CITY OF ALBUQUERQUE

October 19, 2020

**RE: Baylor Drive Property
2635 Baylor Dr. SE
Grading and Drainage Plan
Engineer's Stamp Date: 10/16/20
Hydrology File: M16D044**

**RE: BAYLOR DRIVE PROPERTY
2635 BAYLOR DR. SE
GRADING AND DRAINAGE PLAN
ENGINEER'S STAMP DATE: 08/07/19
HYDROLOGY FILE: M16D044**

GR-1

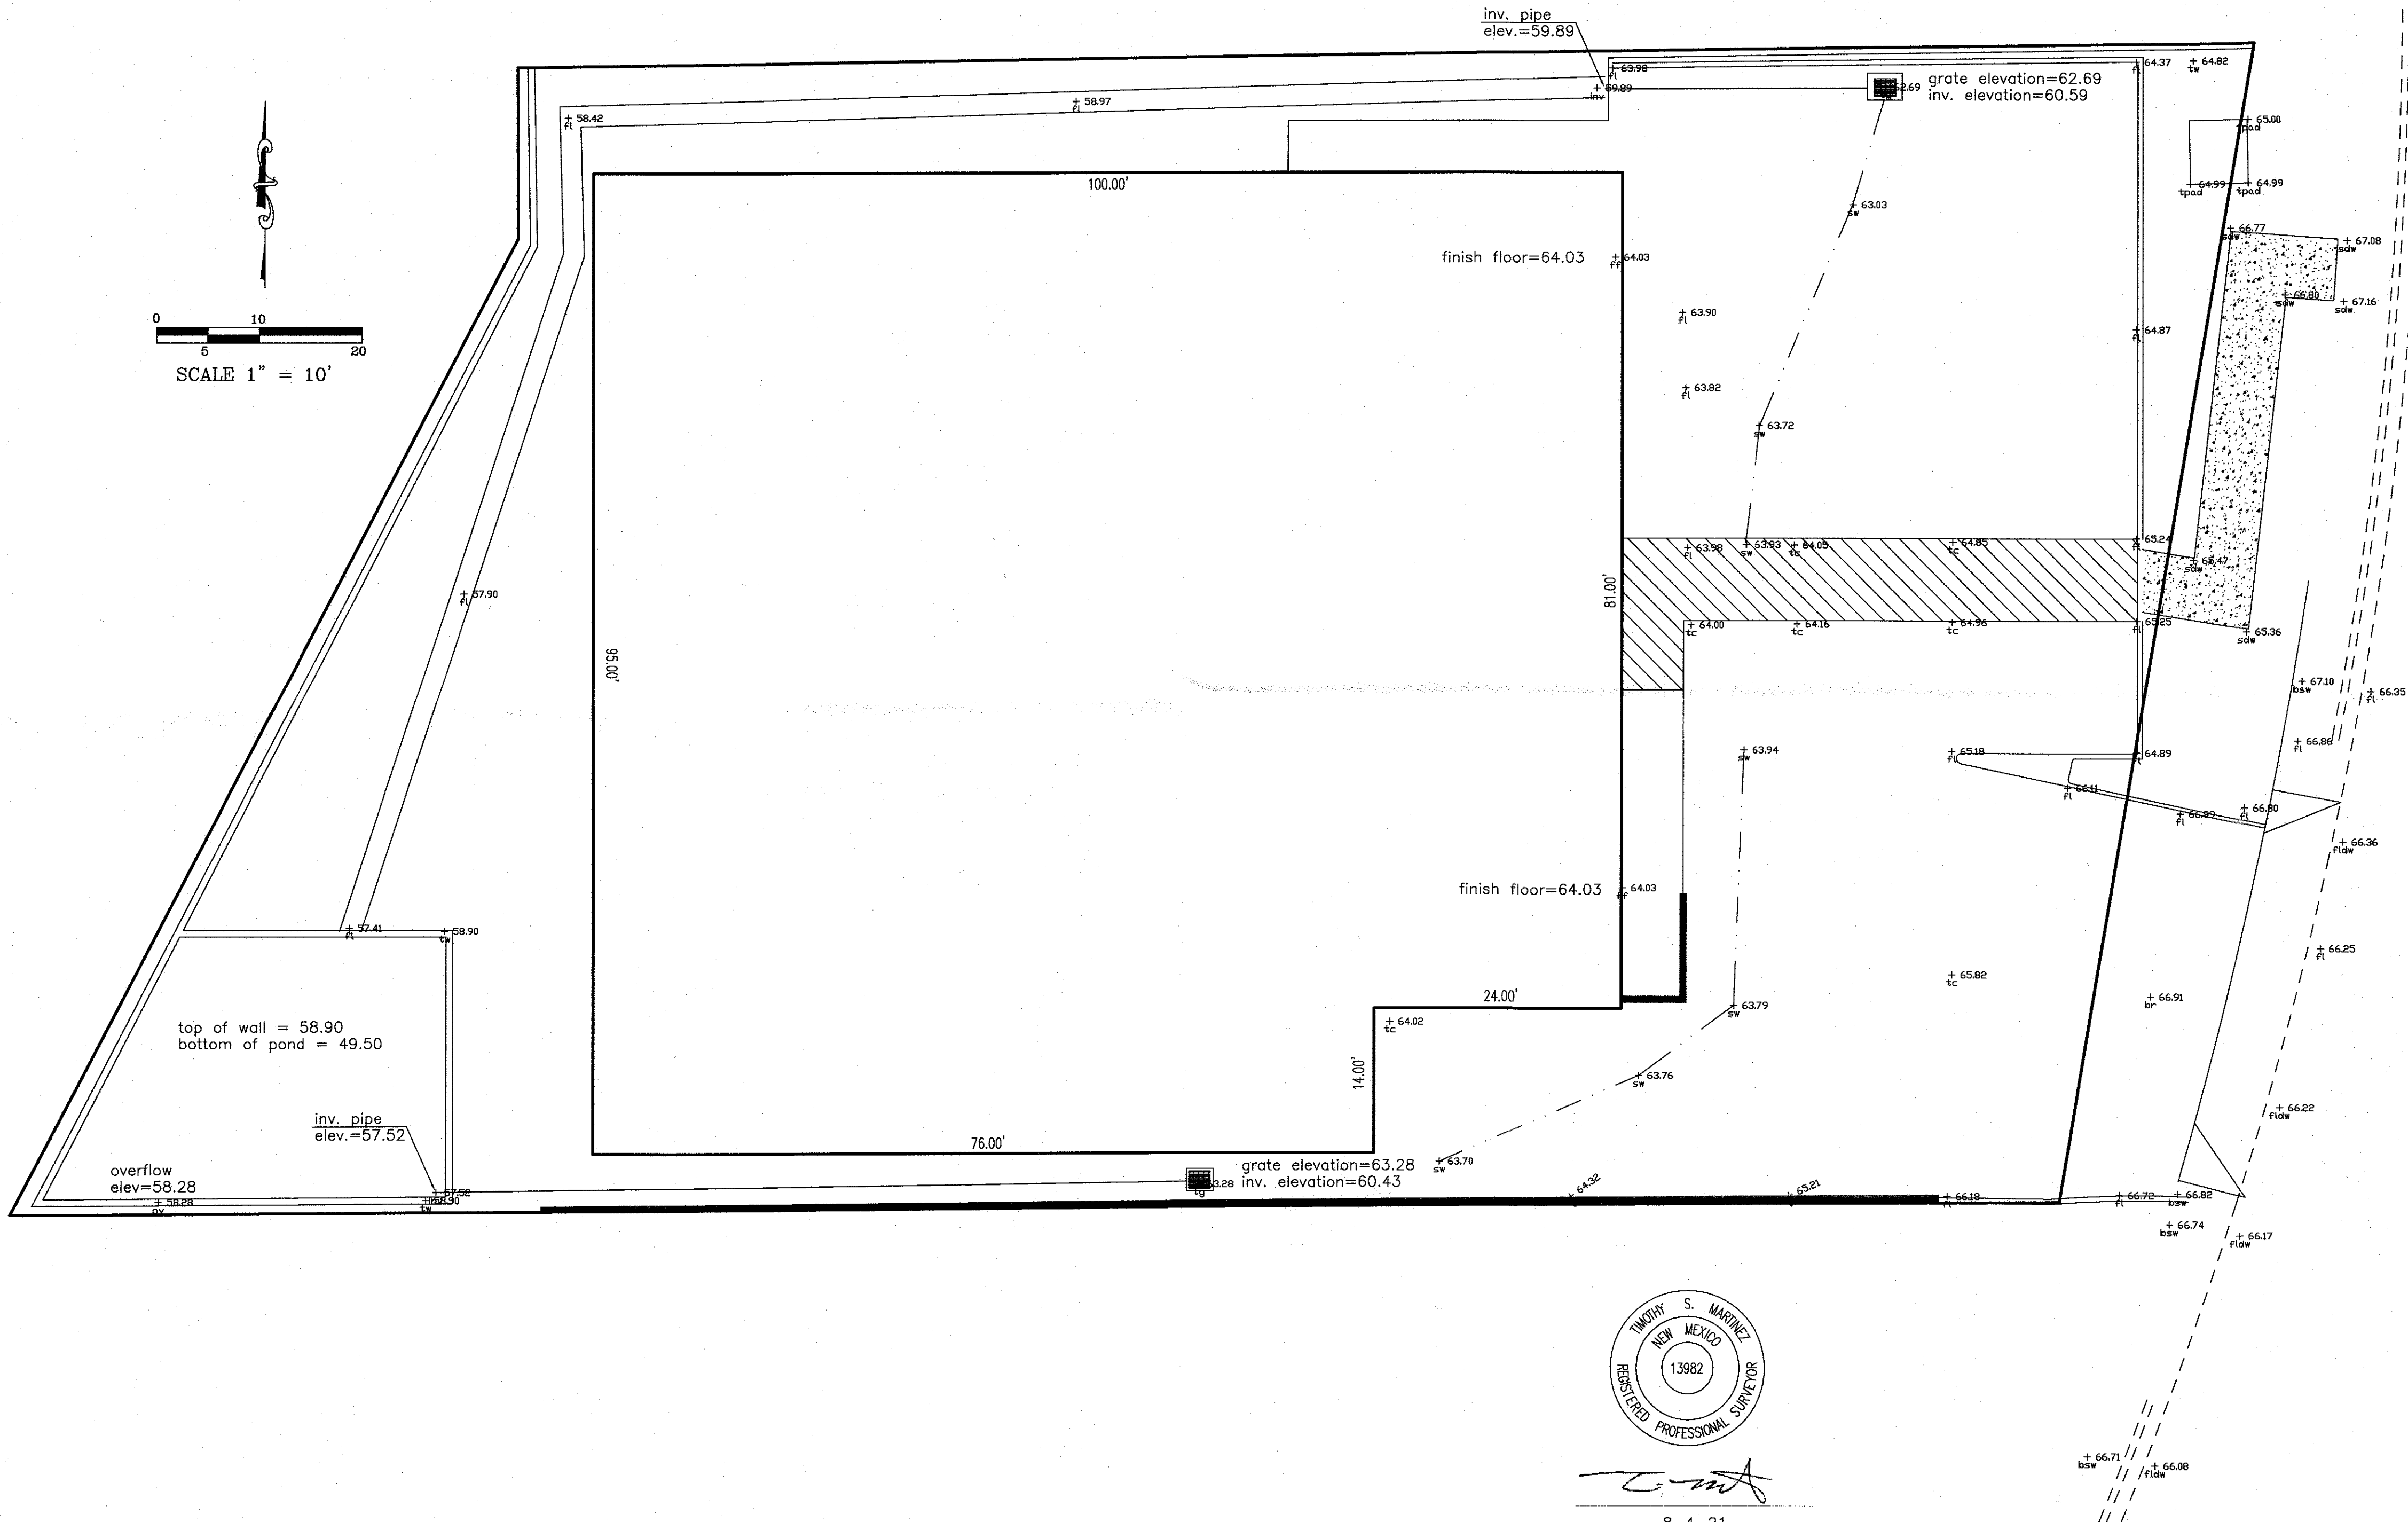
1. Provide the existing and / or proposed grades on both sides of the proposed retaining wall.
Response: Additional spots have been added adjacent to the proposed retaining wall.

6. Please fix several overlapping text and missed placed text.

Response: Overlapping text has been fixed.
